Phone: 0300 123 6780  
Email: [developeras@lancashire.gov.uk](mailto:developeras@lancashire.gov.uk)  
Your ref: 3/2025/0696  
Our ref: 3/2025/0696/HDC/KW  
Date: 23 September 2025

**Location:** Markhor Eaves Hall Lane West Bradford BB7 3JG  
**Proposal:** Proposed demolition of existing bungalow, to be replaced with the erection of a new dormer bungalow on existing site.  
**Grid Ref:** 373856 444865

The Local Highway Authority (LHA) are in receipt of an application for the proposed demolition of the existing bungalow, to be replaced with the erection of a new dormer bungalow on the existing site at Markhor, Eaves Hall Lane, West Bradford.

Proposed Site Plan
1:200 Scale

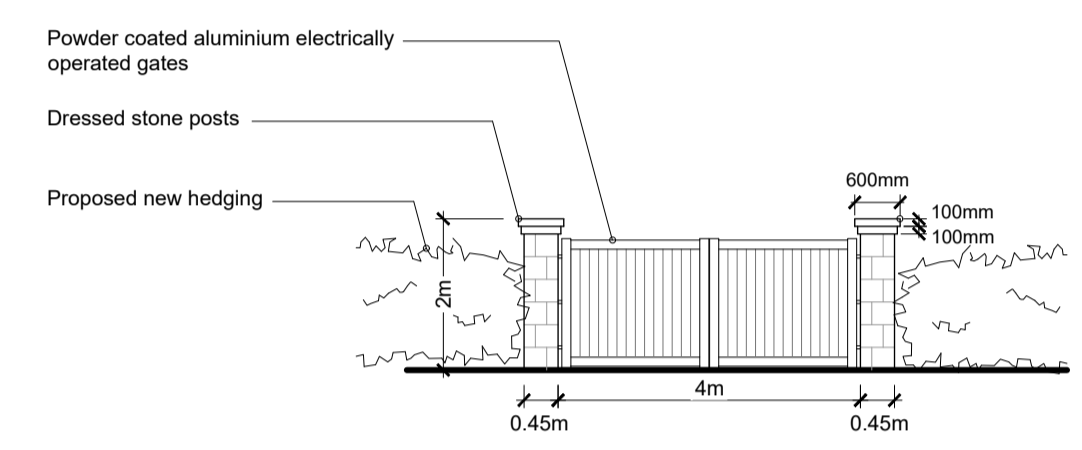
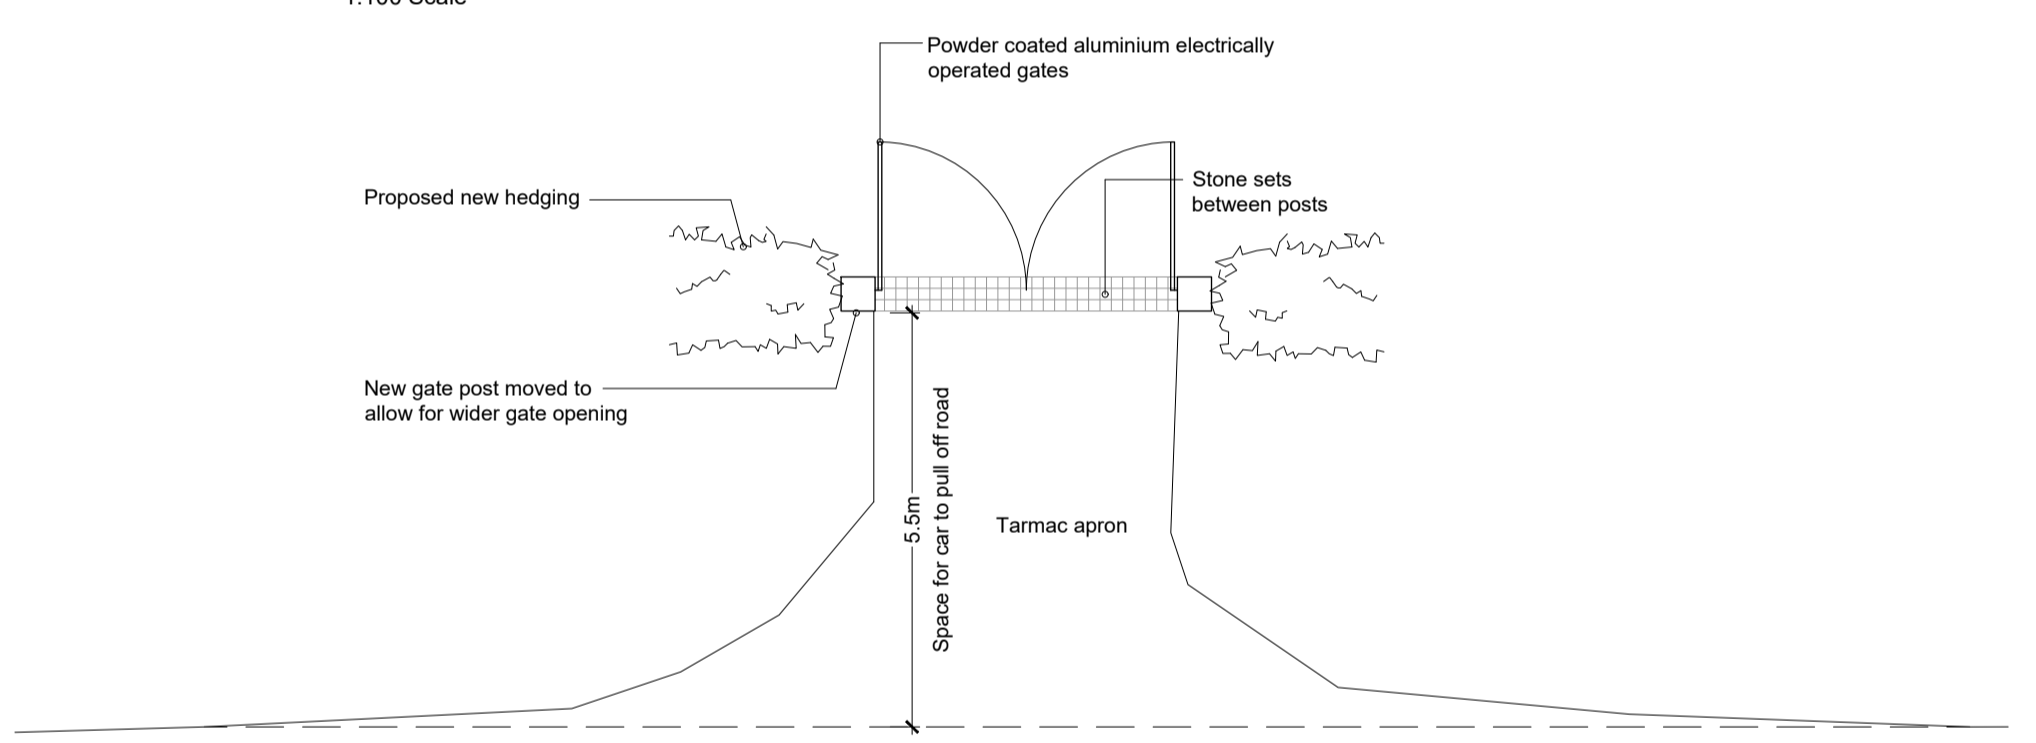
The LHA have reviewed drawing number 7125 P06, Rev D, titled Proposed Site Plan and are aware that the access will be widened slightly. The extended access may require amendments to the existing vehicle crossing within the adopted highway. As such any amendments to the existing vehicle crossing will need to be constructed under a section 171 agreement of the Highways Act 1980. The proposal will also result in the existing gate posts and gates being replaced; the proposed gates sit at least 5m behind the carriageway edge, which is acceptable in this case.

As the access falls towards the highway, surface water from the access and parking area should be collected within the site and drained to a suitable internal outfall.

The LHA have reviewed drawing number 7125 P06, Rev D, titled Proposed Site Plan and is aware that the dwelling complies with the LHAs parking standards as defined in the Joint Lancashire Structure Plan.

The recommended minimum internal dimensions for a double garage are 6m in length and 6m wide. The recommended distance of 6m is based on the length of a large family car (Ford Mondeo Estate 4.58m long), clearance at the rear of the car (200mm), overhang of the garage door (600mm) and room to stand in front of the car and open/close the garage door (600mm). The proposed garage is acceptable in size to support 2 off-street parking spaces.

6. The surface water from the approved access should be collected within the site and drained to a suitable internal outfall. Prior to commencement of the development details of the drainage strategy shall be submitted to and approved in writing by the Local Planning Authority. The scheme shall be implemented in accordance with the approved details.

7. All gates and associated mechanisms to be located outside the adopted highway and the gates to have physical restraints to prevent them from opening onto the adopted highway.
